Hampshire Water Transfer and Water Recycling Project

Draft Statement of Common Ground - Hampshire County Council

PLANNING INSPECTORATE SCHEME NUMBER: WA010002

May 2026

Figure 16.1
 Proposed Development and Mineral Safeguarded Areas and Safeguarded Minerals and Waste Sites
 Sheet 2 of 7

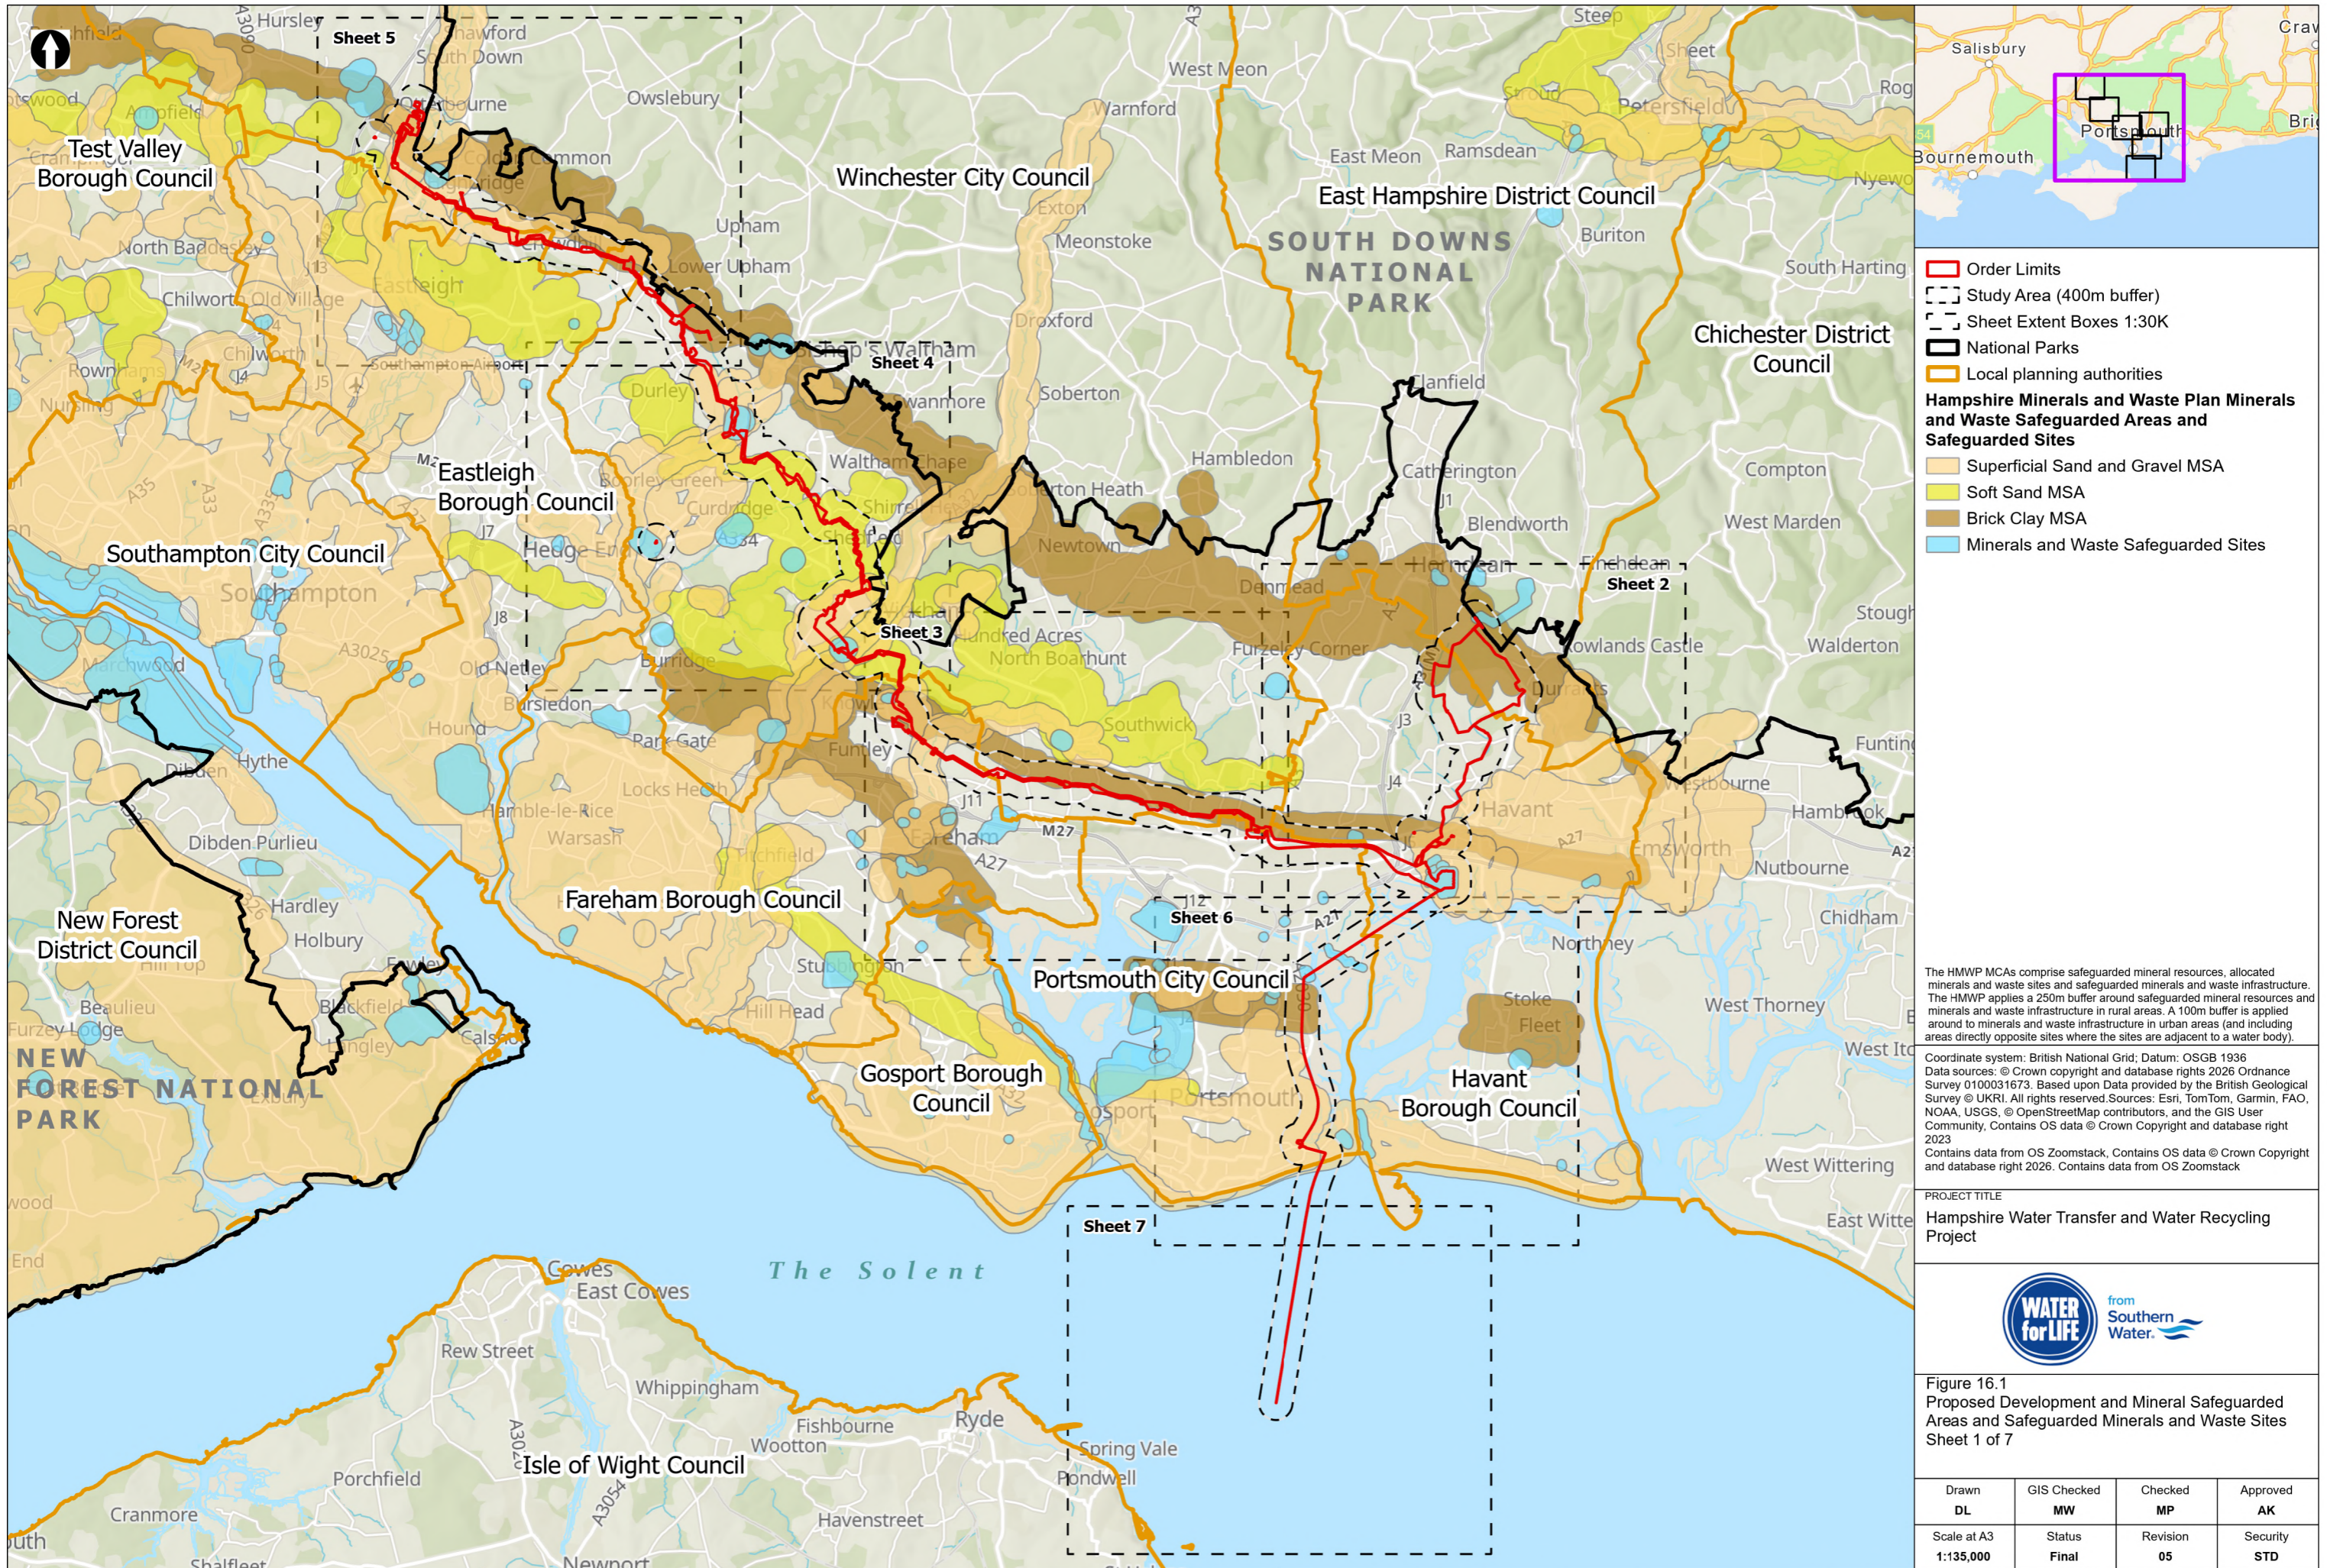
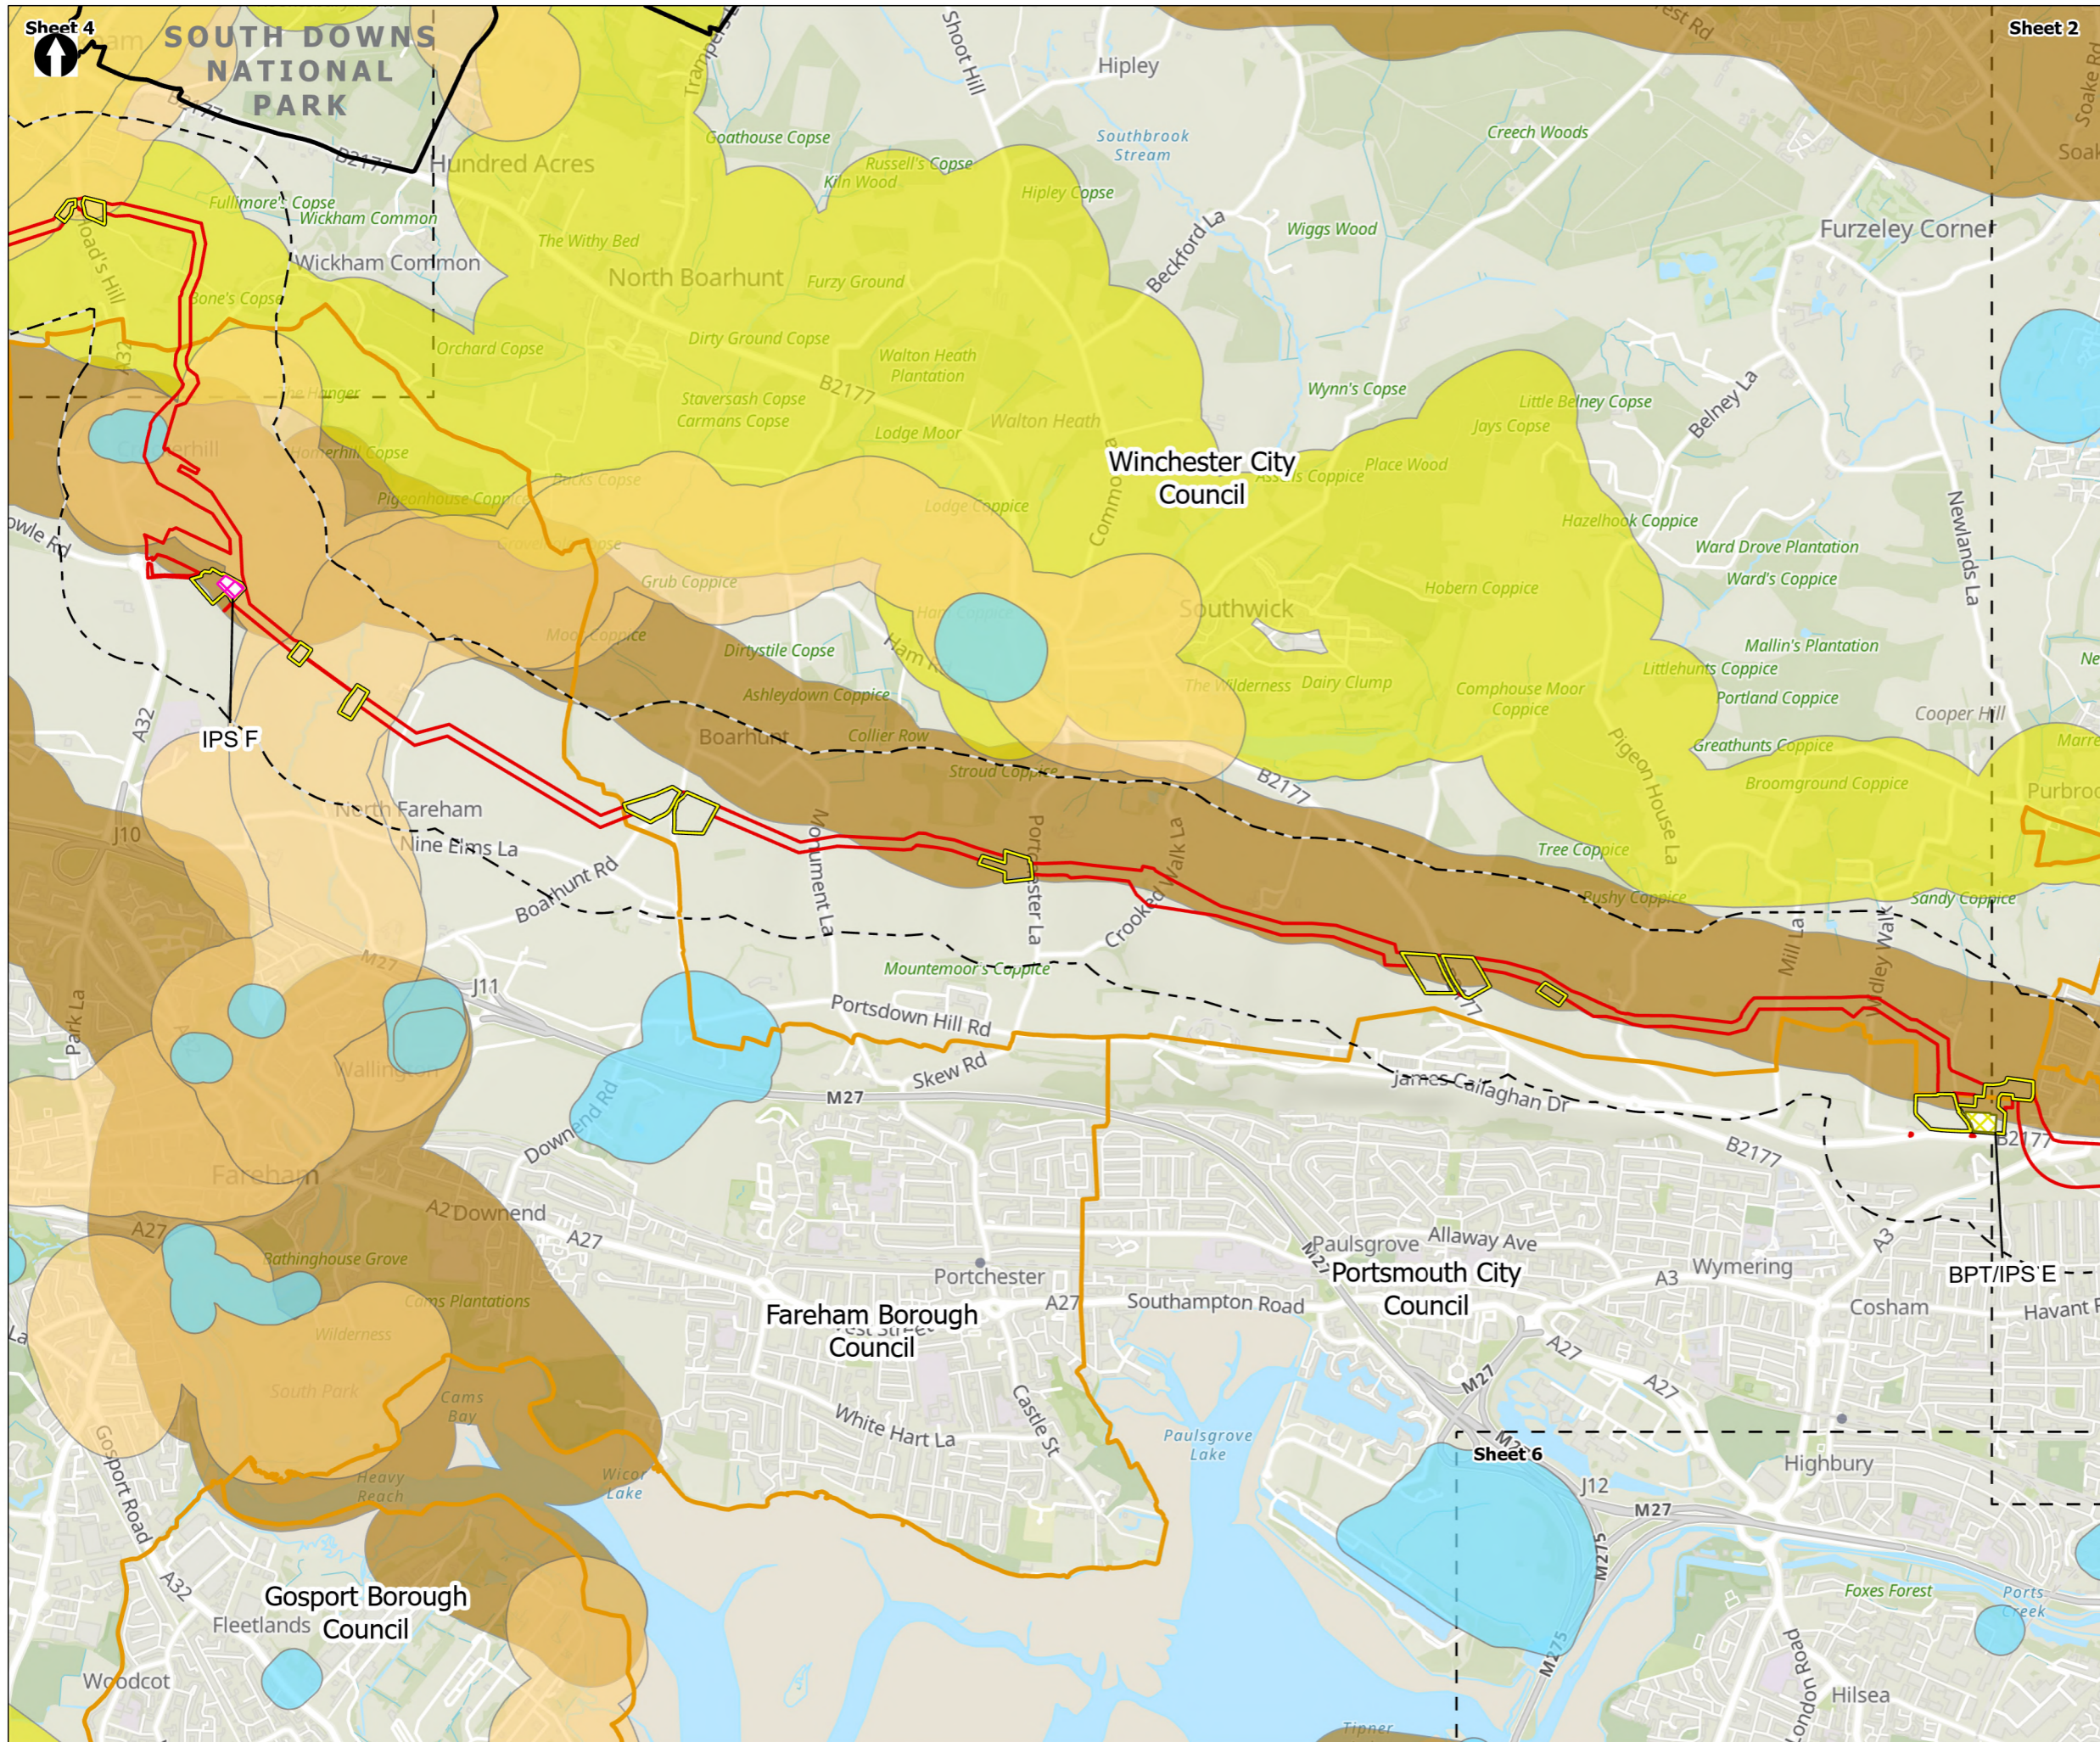
HCC-2022-0064	Resources and waste management - baseline	It is acknowledged that the 100 metres buffer is applied specifically around residential properties in accordance with the Supplementary Planning Document Minerals and Waste Safeguarding in Hampshire adopted in February 2016.	The Applicant acknowledges the HMWPA's position.		Matter agreed with other party.
HCC-2024-0189	Resources and waste management - baseline	The HMWPA supports the prior extraction of soft sand from Five Oaks Farm, in principle, to prevent sterilisation. The onus is on the landowner to pursue agreement with the developer to resolve the issue of the development of sand extraction at the Five Oaks Site, as well as the appropriate permissions from the HMWPA - but continue to bear in mind soft sand resource safeguarding and sterilisation policies of the HMWP (2013) and the emerging HMWP update.	The HMWPA supports the prior extraction of soft sand from Five Oaks Farm, in principle, to prevent sterilisation. The onus is on the landowner to pursue agreement with the developer to resolve the issue of the development of sand extraction at the Five Oaks Site, as well as the appropriate permissions from the HMWPA - but continue to bear in mind soft sand resource safeguarding and sterilisation policies of the HMWP (2013).	ES Appendix 16.1 Mineral Safeguarding Assessment, Volume II (Document reference 6.2, DCO Volume 6).	Matter agreed with other party.

HCC-2024-0159	Resources and waste management - assessment	The HMWPA supports the structured approach to assessing regional waste capacity impacts in the ES. HMWPA understands and is satisfied that the Outline CEMP (Document reference 7.1, DCO Volume 7) includes measures to produce, implement and maintain a Site Waste Management	The Applicant acknowledges the HMWPA's position.	Outline Construction Environmental Management Plan (Document reference 7.1, DCO Volume 7). ES Chapter 16 Resources and waste management, Volume I (Document	Matter agreed with other party.

HCC-2025-SC-0027	Resources and waste management - mitigation	The HMWPA notes that design refinement 24 - From Mortimers Lane (B3037) near Lower Upham to Highbridge Road (B3335), west of Brambridge, will have minimal effect on how much of the pipeline easement is within the Mineral Safeguarding Area. The Mineral Resource Assessment (MRA) will be required to understand the Applicant's assessment of how to deal with extracted minerals.	The Applicant has prepared an Appendix 16.1 Mineral Safeguarding Assessment, Volume II (Document reference 6.2, DCO Volume 6) accompanying the ES Chapter 16 Resources and waste management, Volume I (Document reference 6.1, DCO Volume 6) in response to the proportion of the land within the Order Limits coinciding with the Mineral Consultation Areas (MCA) as identified by HCC in its adopted Hampshire Minerals and Waste Plan. The Outline CEMP (Document reference 7.1, DCO Volume 7) requires the Contractor to develop a Minerals Management Strategy (MMS) as part of the	ES Appendix 16.1 Mineral Safeguarding Assessment, Volume II (Document reference 6.2, DCO Volume 6). ES Chapter 16 Resources and waste management, Volume I (Document reference 6.1, DCO Volume 6). Outline Construction Environmental Management	Matter agreed with other party.
